Application no: H14-0189-15

Description: Proposed replacement dwelling

Location: RIVETT
LANGHOLE DROVE
PINCHBECK
SPALDING
PE11 3XP
PE11 3XP

Amendment: Move position of property over the east by 3 metres
(dwg. no. AB-02D)

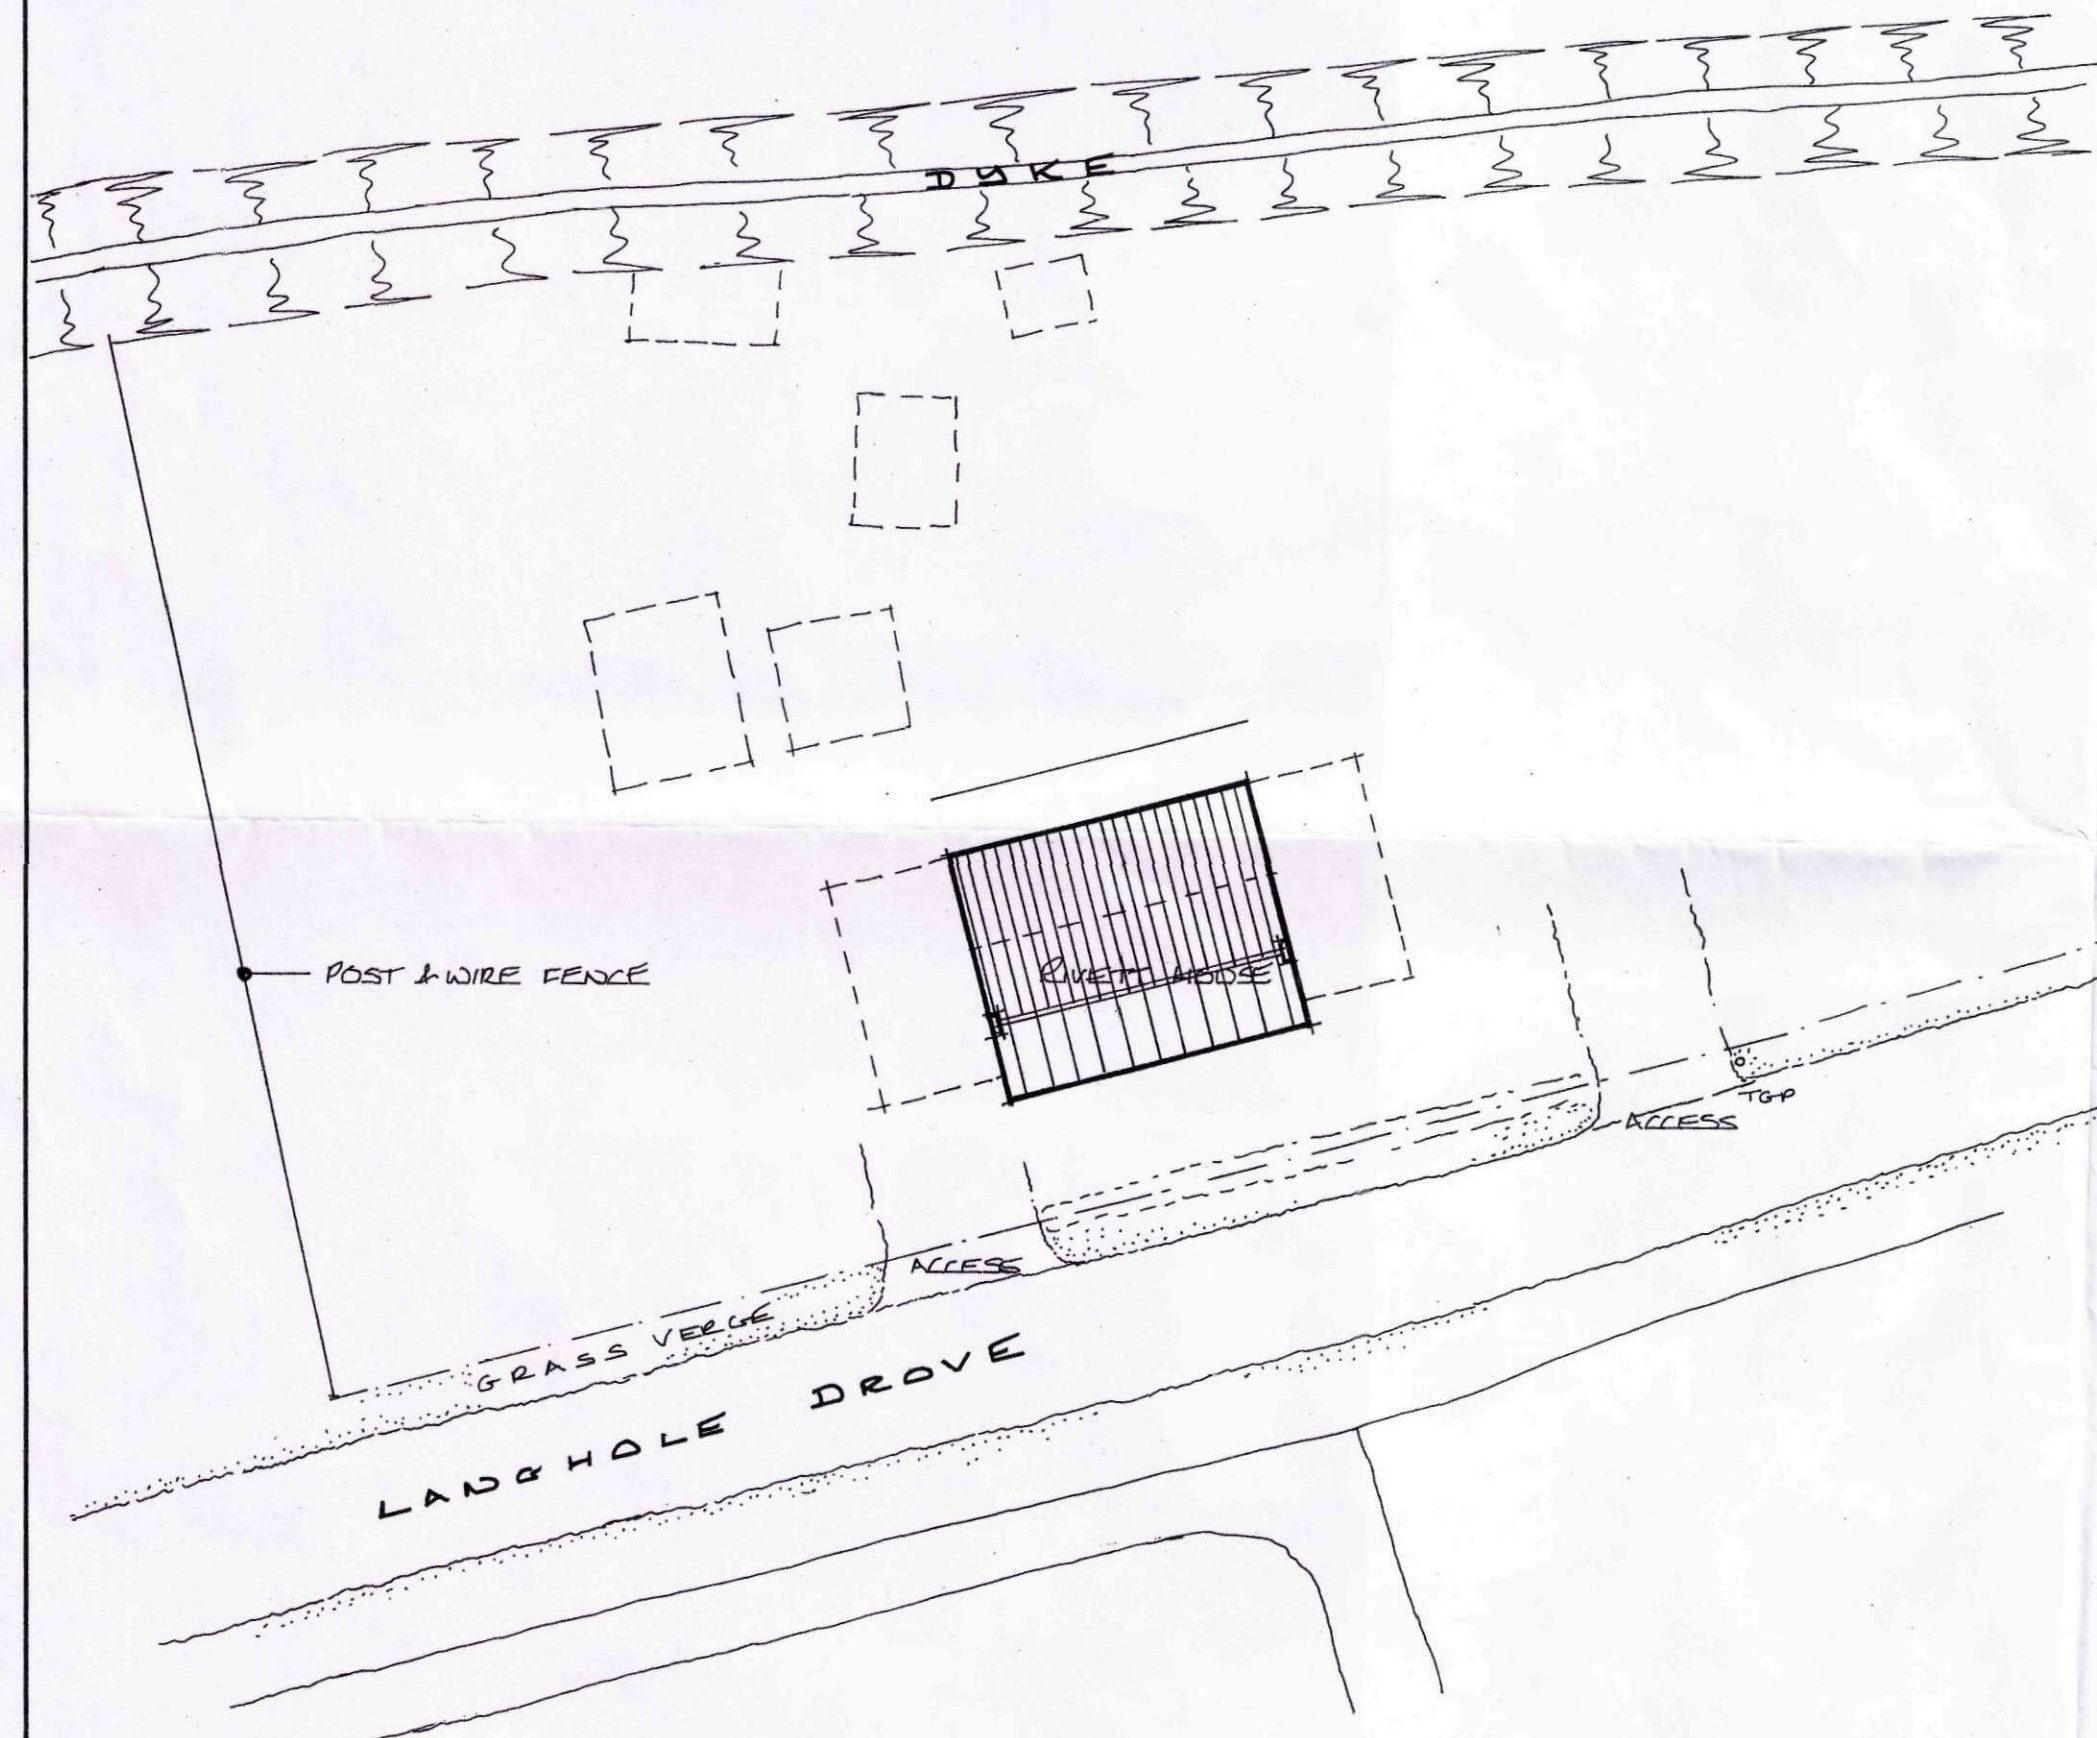
Existing and Proposed Site Plans AB/02RevD.
